**KIRKLEES METROPOLITAN COUNCIL
INVESTMENT & REGENERATION SERVICE**

Reference No: 2018/62/93906/E

Site Address: 4-5, Mazebrook, Drub, Cleckheaton, BD19 4BT

Description: Demolition of barn/workshop and erection of detached dwelling with attached garage

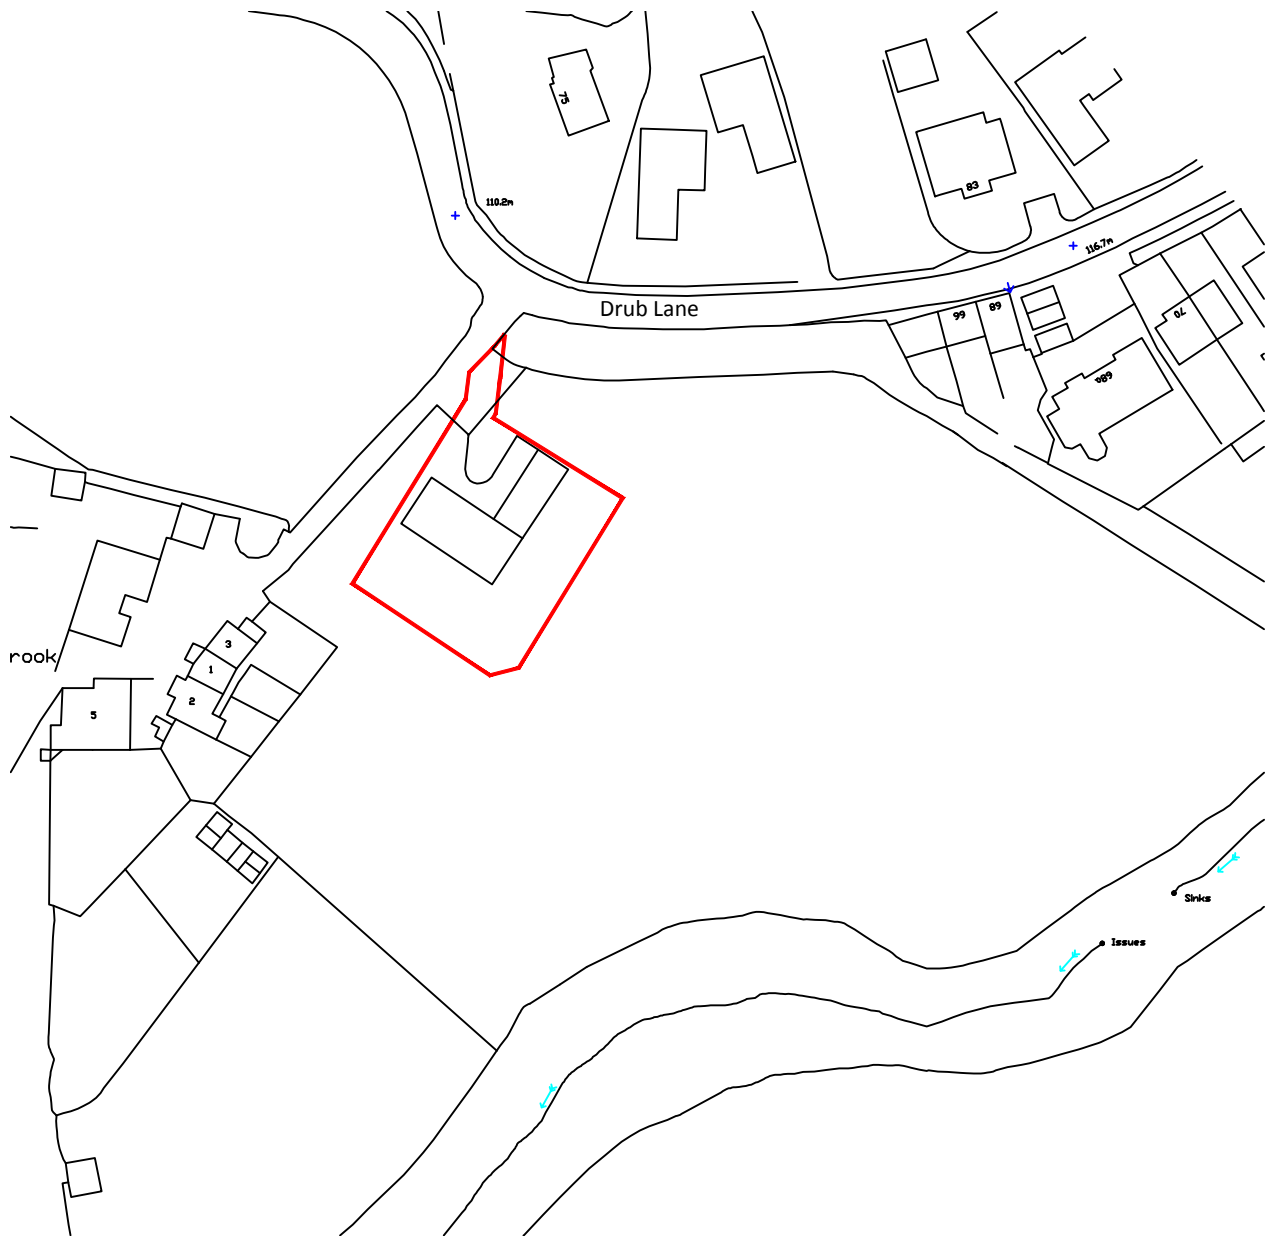
8. The residential curtilage shall be restricted to the area outlined in red on the submitted location plan (0001B).

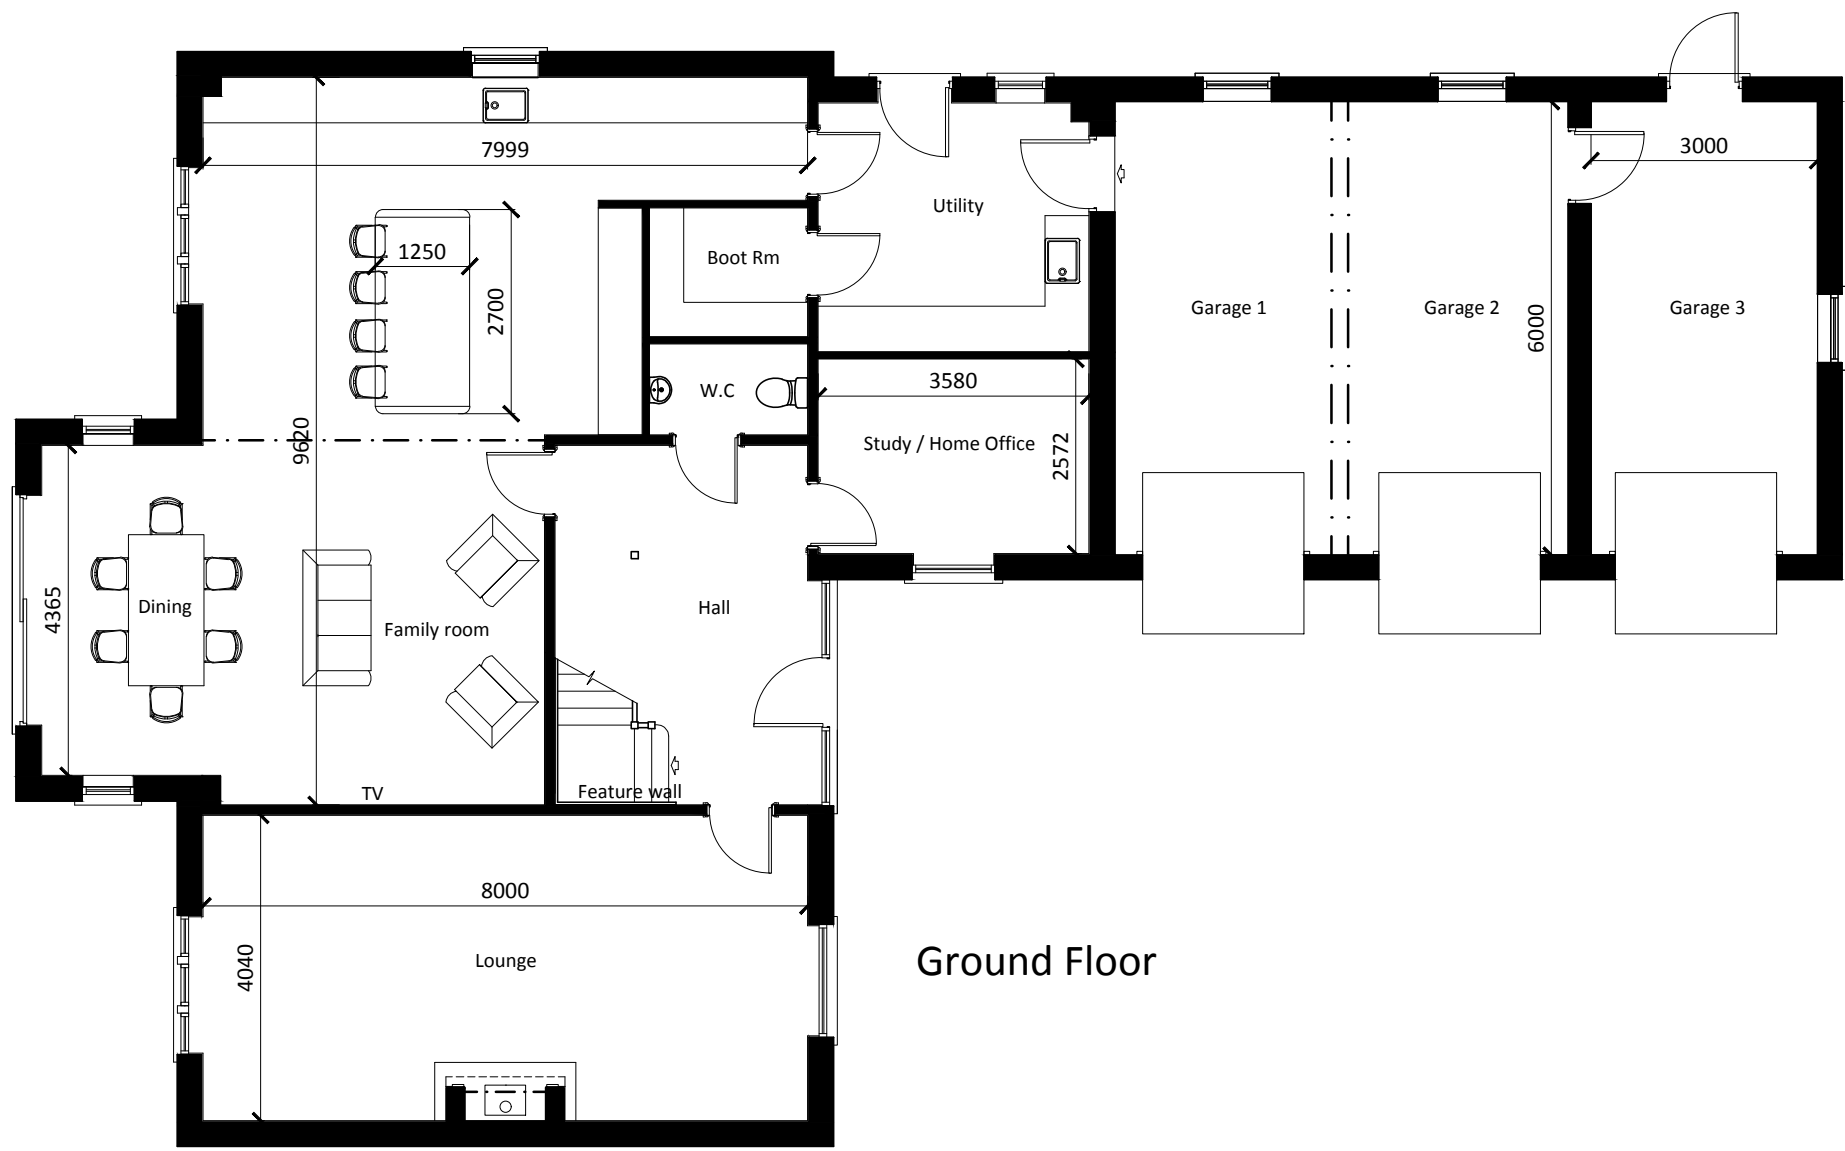
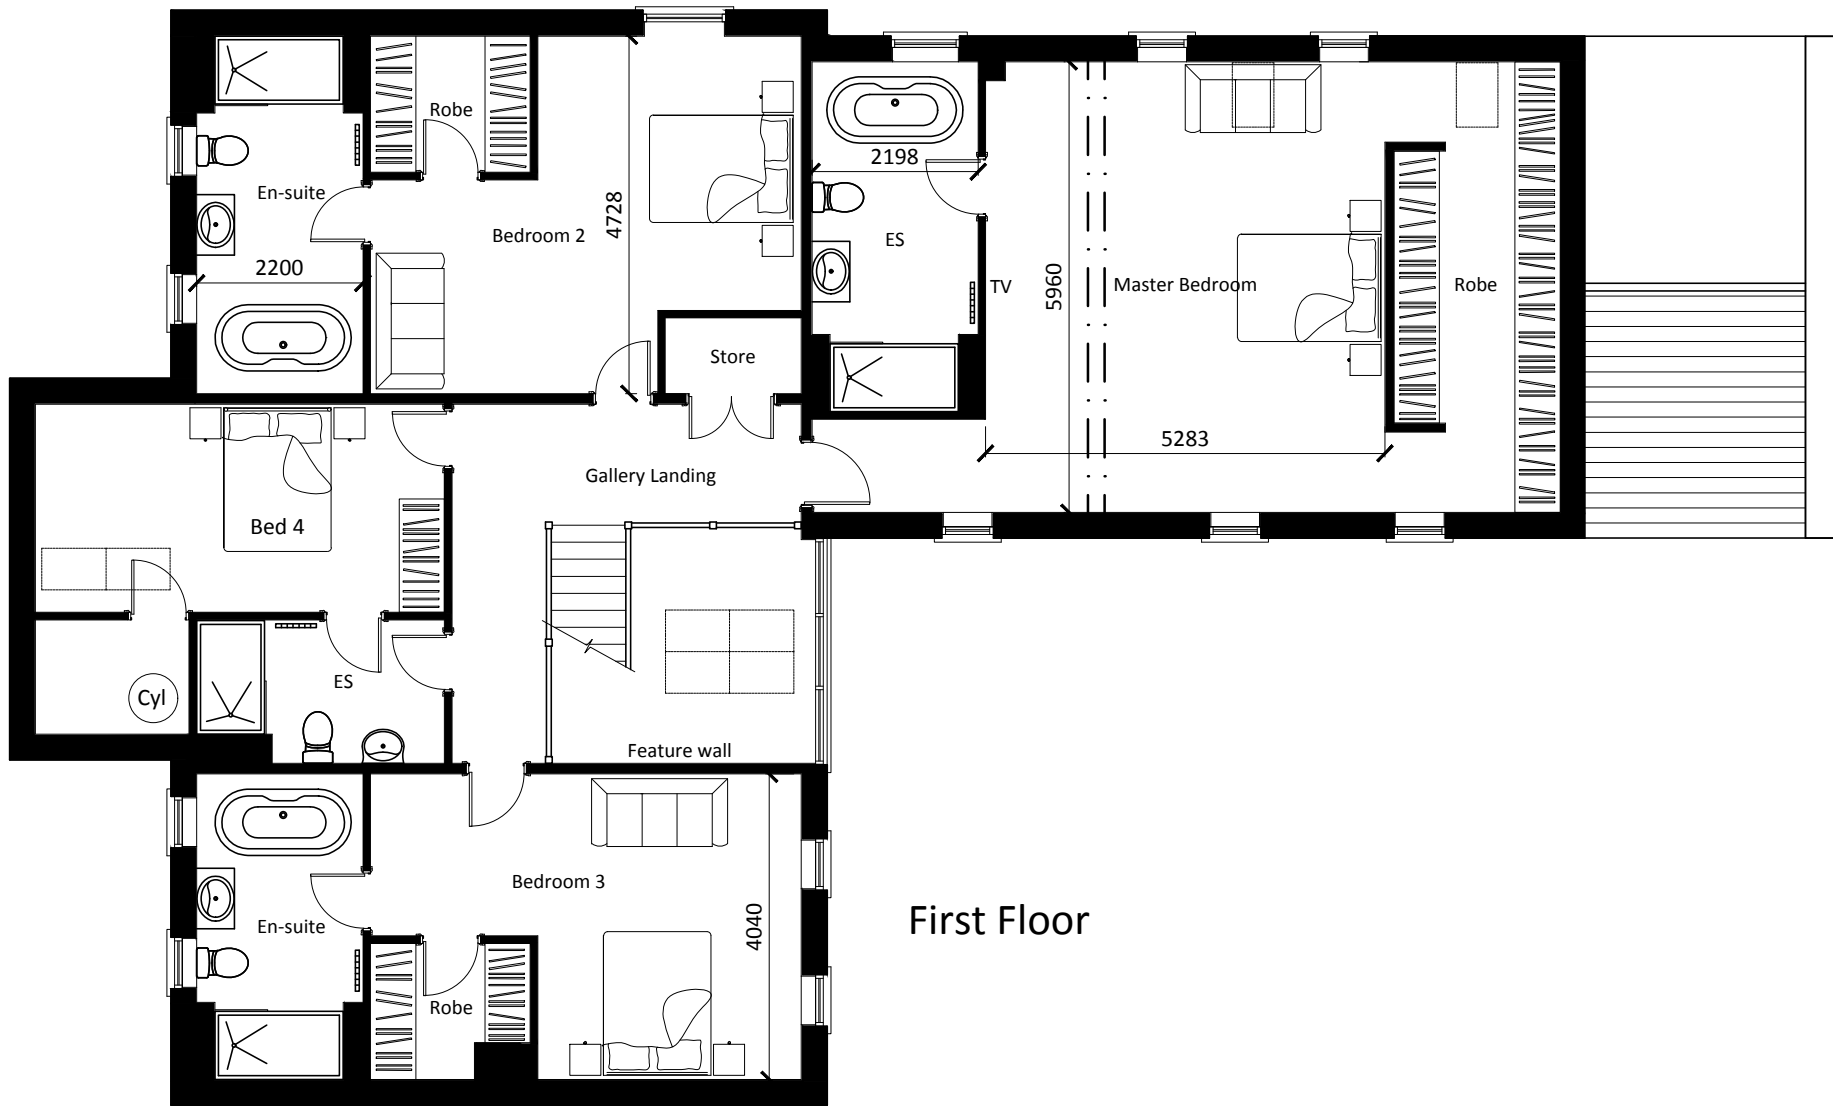
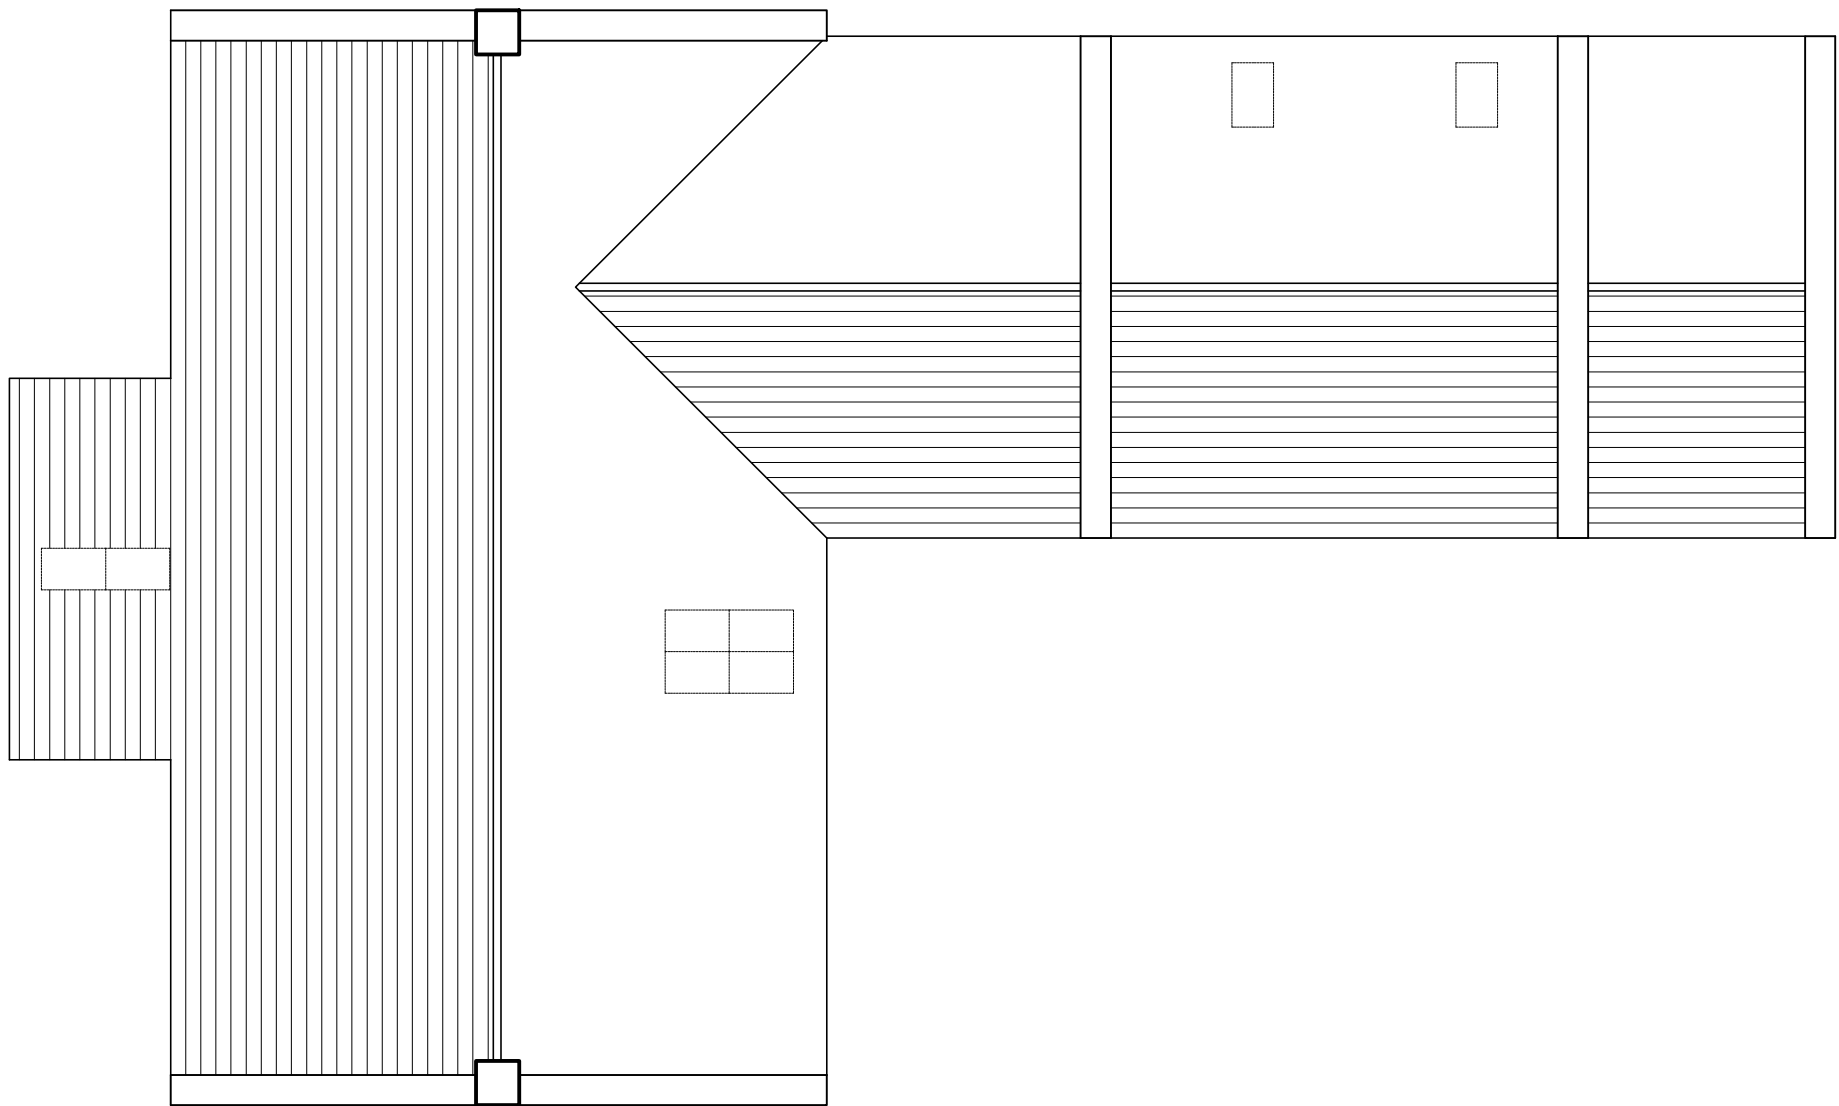
Through the course of the application, the case officer raised concerns with regard to the impact of the development on the openness of the Green Belt. Consultation responses also raised a requirement for amended/additional information. On this basis, the agent provided the following:

- Amended Elevations indicating amended roof pitch
- Proposed Street Scene
- Additional information relating to proposed sewage treatment plant
- Amended sight lines in accordance with KC Highways DM consultation response

- The height of the building is the same as the previously approved scheme;
- The proposed footprint of the development is 9% less than that of the existing barn;
- Reduction in roof pitch from 30 to 27.5 degrees.
